**KIRKLEES METROPOLITAN COUNCIL  
INVESTMENT & REGENERATION SERVICE**

**DELEGATED DECISION TO DETERMINE PLANNING APPLICATIONS**

Reference No:	<b>2023/62/92072/W</b>
Site Address:	164, Lockwood Road, Lockwood, Huddersfield, HD1 3QR
Description:	Conversion of basement to form self contained apartment and refurbishment of existing dwelling with associated internal and external alterations
Recommending Officer:	Katie Chew

**DECISION - REFUSED**

Rear Elevation
1 : 100

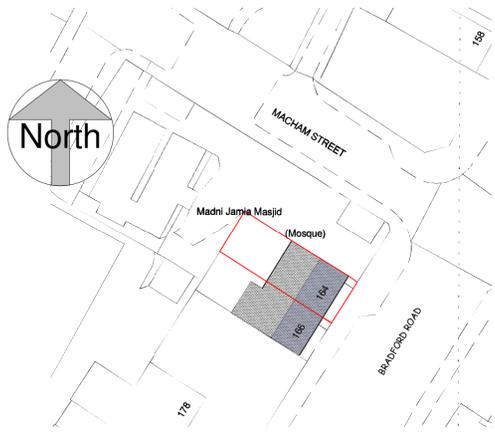
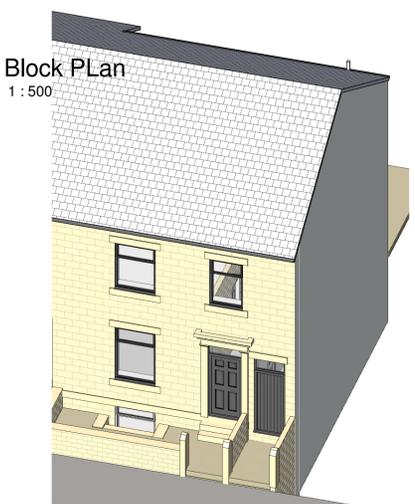
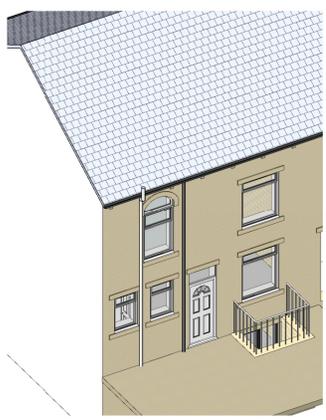
However, the lack of bin storage arrangements, even if these were to the rear there is no access to the rear space from the apartment, is contrary to Policy LP24d of the Kirklees Local Plan. In addition, it is likely in these circumstances that bins would be stored on the footway, which is harmful to highway safety and visual amenity.

1. The proposed development would not provide on-site provision for the storage of refuse bins for future residents. This would likely require the storage of refuse bins on the public footway which is not in the interests of highway safety or visual amenity. This is contrary to Policies LP21 and LP24(d) of the Kirklees Local Plan and the Waste Management Design Guide for new developments 2020.

Cellar - P
1 : 50

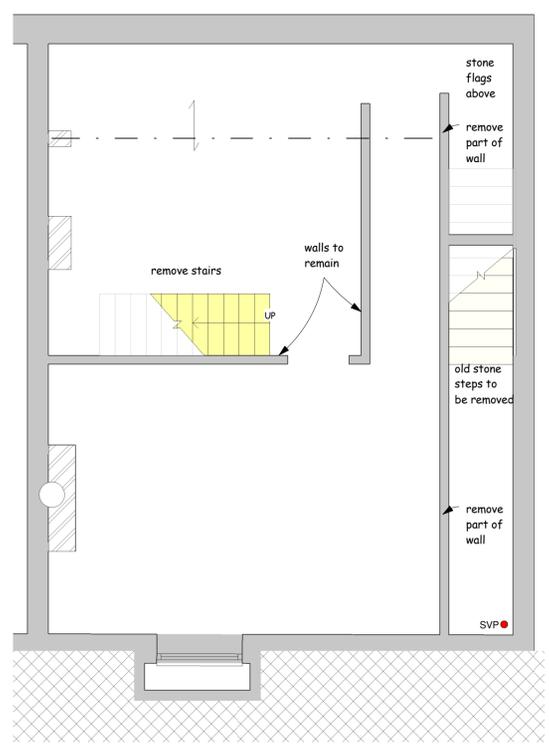
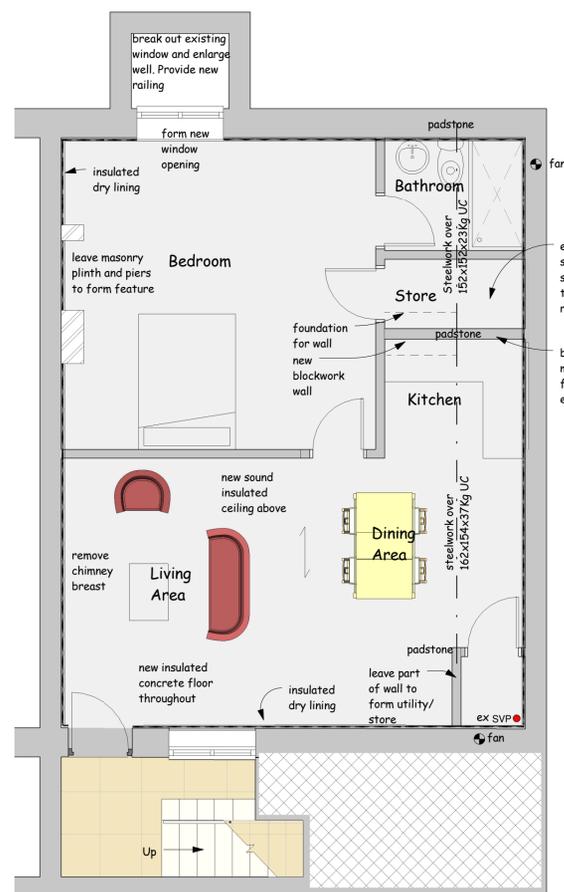
In this instance, Officers note that the proposed basement apartment would provide sufficient internal floorspace in line with the Nationally Described Space Standards for 2 persons. Moving on to outlook and light however, Officers have significant concerns in respect of the lack of outlook and natural light gained into the apartment from the 2 lightwells (to the front and rear). Future occupiers would only be able to gain oblique views out of these windows given the differences in ground levels. Furthermore, to the front of the dwelling there is an existing stone wall and railings running along the eastern boundary, this is also where bin collection points are located. This would result in some additional visual impact on the outlook of the future occupiers from this window due to additional bulk and visual clutter outside of the well, adding to a sense of enclosure. It is therefore considered that whilst some natural light will be available there would be an overdependence on artificial lighting combined with a very limited outlook towards deep lightwells, detrimentally affecting the living conditions of future occupiers.

In conclusion, taking the above into account it is considered that the proposed basement apartment would provide sufficient internal living accommodation, but would not provide a reasonable amount of natural light and outlook to be gained from the apartment to provide a high standard of amenity for future occupants. This would result in the proposal being contrary to Policy LP24(b) of the Kirklees Local Plan, Chapter 12 of the NPPF and Principle 6 of the Housebuilders Design Guide SPD.

1. The habitable room windows to serve the proposed basement apartment would, by reason of their relationship with existing ground levels, experience a severely restricted and poor outlook which would not result in a high standard of amenity to future occupants of the dwelling. This would therefore be contrary to the aims of paragraph 130 (f) of Chapter 12 of the National Planning Policy Framework, Principle 6 of the Housebuilders Design Guide Supplementary Planning Document and LP24(b) of the Kirklees Local Plan.
